**KIRKLEES METROPOLITAN COUNCIL
INVESTMENT & REGENERATION SERVICE**

**DELEGATED DECISION TO DETERMINE APPLICATIONS FOR
CONSENT, AGREEMENT OR APPROVAL REQUIRED BY CONDITION**

Reference No: 2021/44/91762/W

Site Address: Baitul Tauheed Mosque, Fartown Pavilion, Spaines Road, Fartown, Huddersfield, HD2 2QA

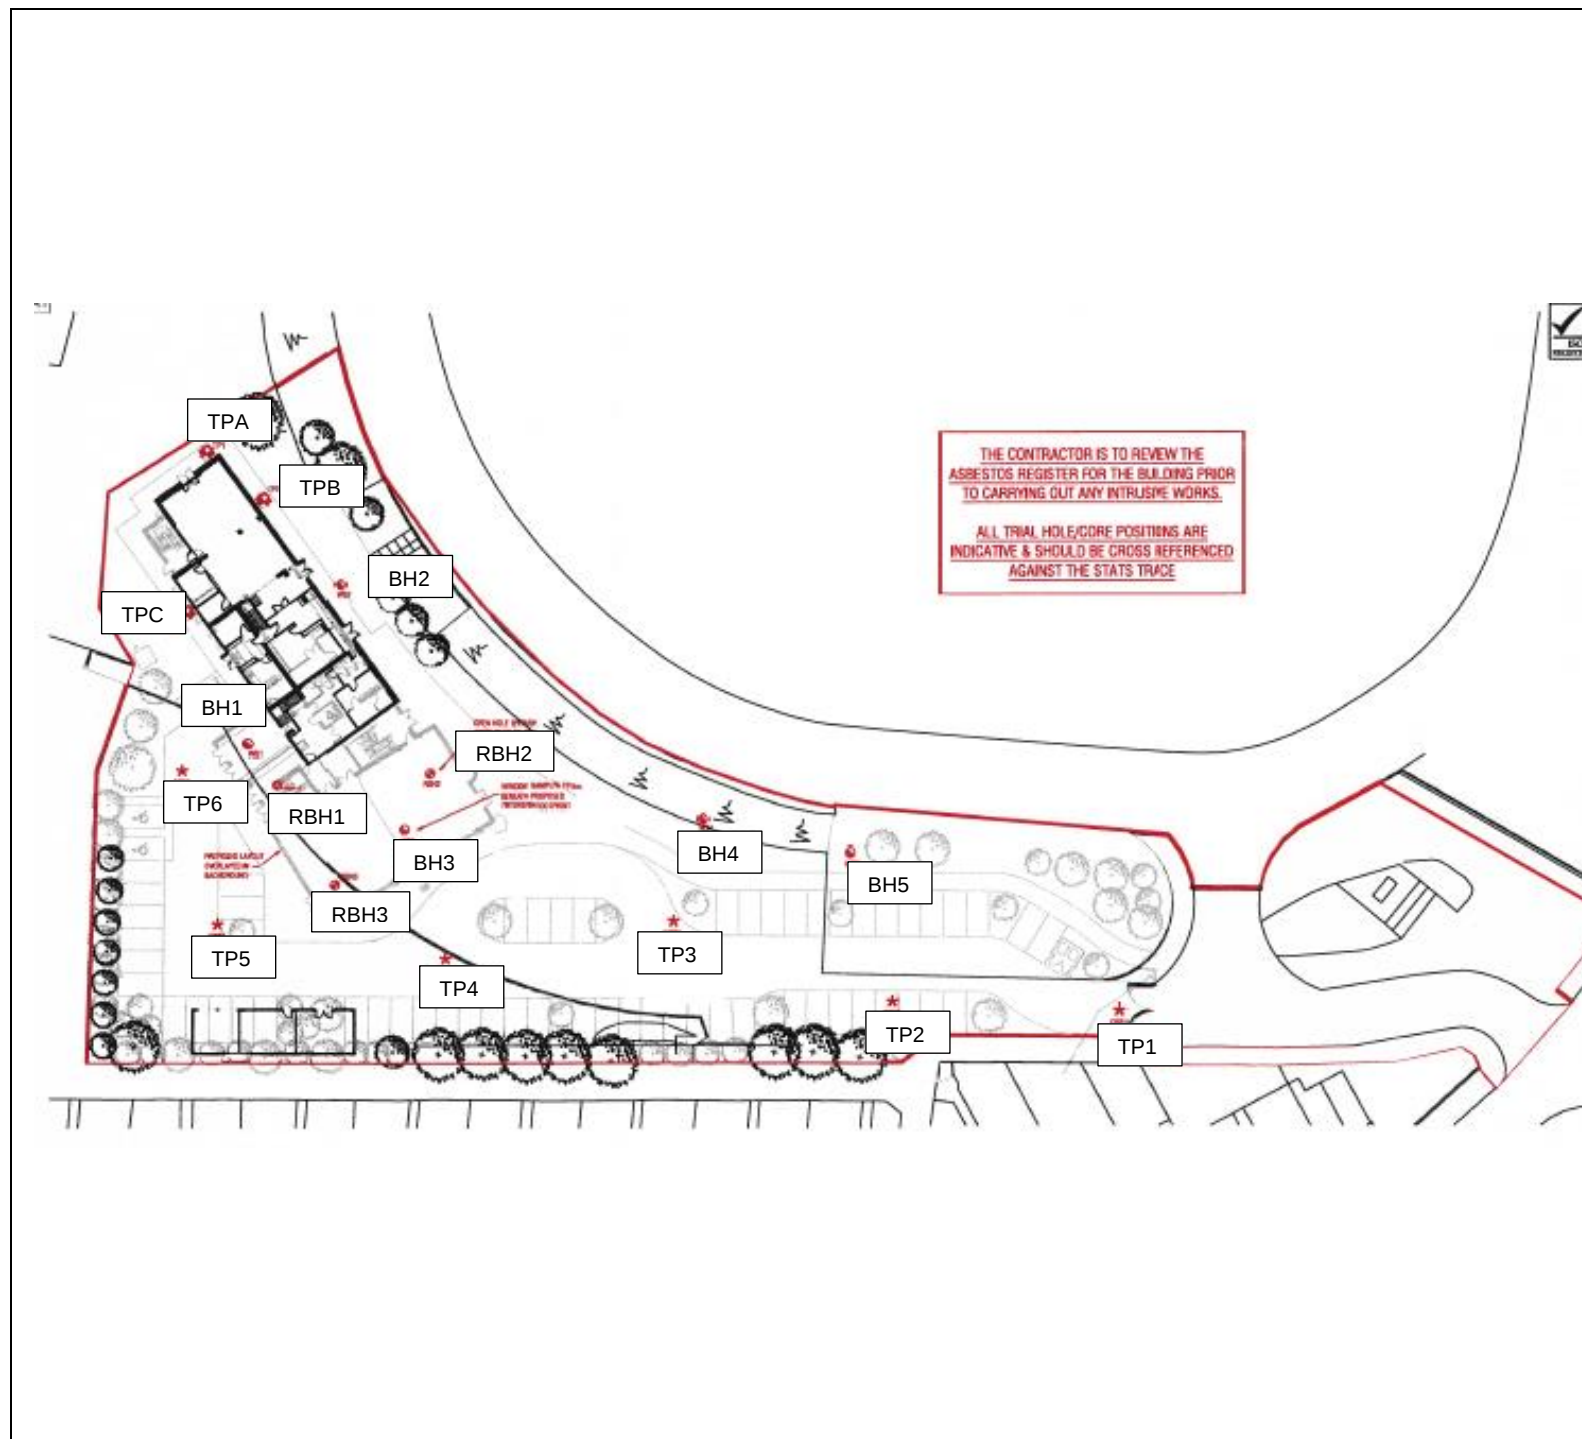
1. Regarding hotspot delineation at BH3 and BH5, the report reads that '*any visually stained or olfactory odour materials will be excavated*' and '*excavations will continue both horizontally and vertically until 'clean' soils are exposed*'. It is unclear from this statement whether any excavations will take place if no visual or olfactory material is observed at the BH3 and BH5 sample locations. Visual and olfactory determination of contaminated soils is subjective, and contamination may exist regardless of these field signs. Further clarification is required to confirm delineation will continue if in the absence of visual or olfactory contamination and the proposed lateral and horizontal extents for excavation must be provided.
